WEST SUSSEX COUNTY COUNCIL CONSULTATION

TO:	Arun District Council FAO: Anita Gardner
FROM:	WSCC - Highways Authority
DATE:	9 July 2019
LOCATION:	52 High Street, Littlehampton, BN17 5SY
SUBJECT:	LU/191/19/PD Notification for Prior Approval for a Change of Use from Financial and Professional Services (Class A2) to Restaurant (Class A3) and alterations to High Street shopfront, provision of extract duct & formation of bin store.
DATE OF SITE VISIT:	N/A
RECOMMENDATION:	Advice
S106 CONTRIBUTION TOTAL:	£N/A

PROPOSED RESTAURANT PLAN
 52 HIGH STREET, LITTLEHAMPTON.
 GRAHAM NICOLLS LTD. BUILDING DESIGN+TECHNOLOGY.

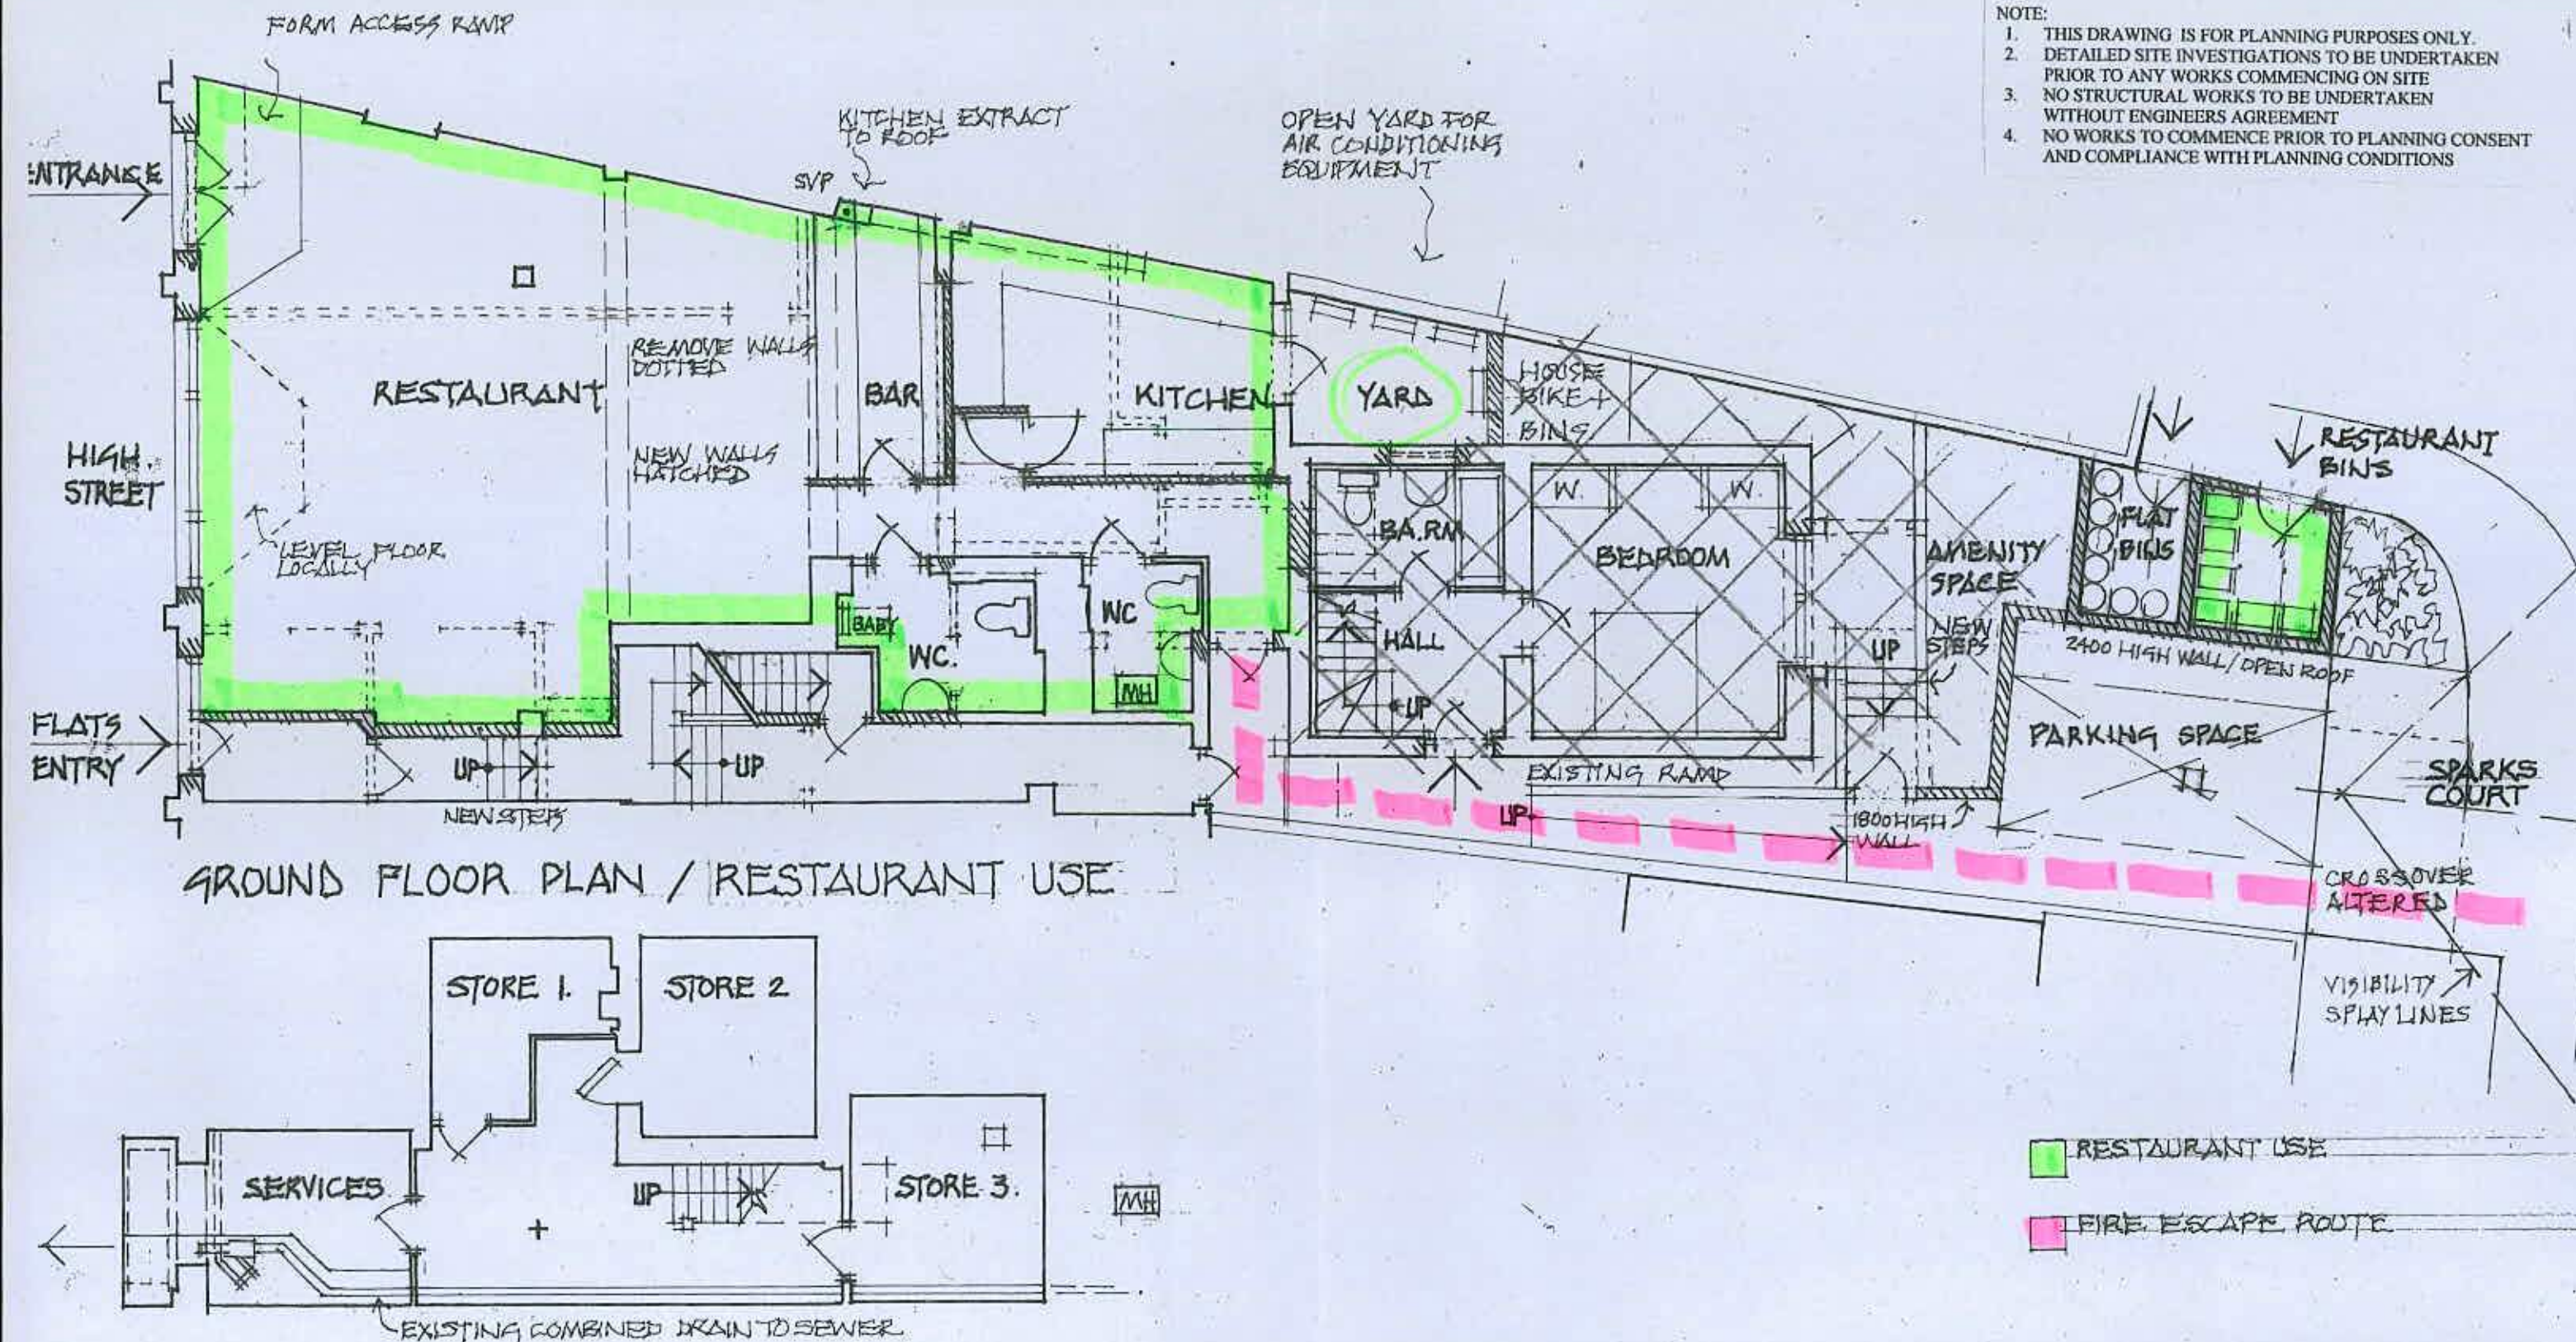
1 car parking space to the rear of the property is proposed. For the proposed Class A3 use, the WSCC car parking supplementary planning guidance suggests that a maximum parking requirement of 1 car parking space per 5m² of restaurant floor space would be required, plus 2 parking spaces per bar for staff. Therefore a maximum of 19 car parking spaces may be provided for this proposal.
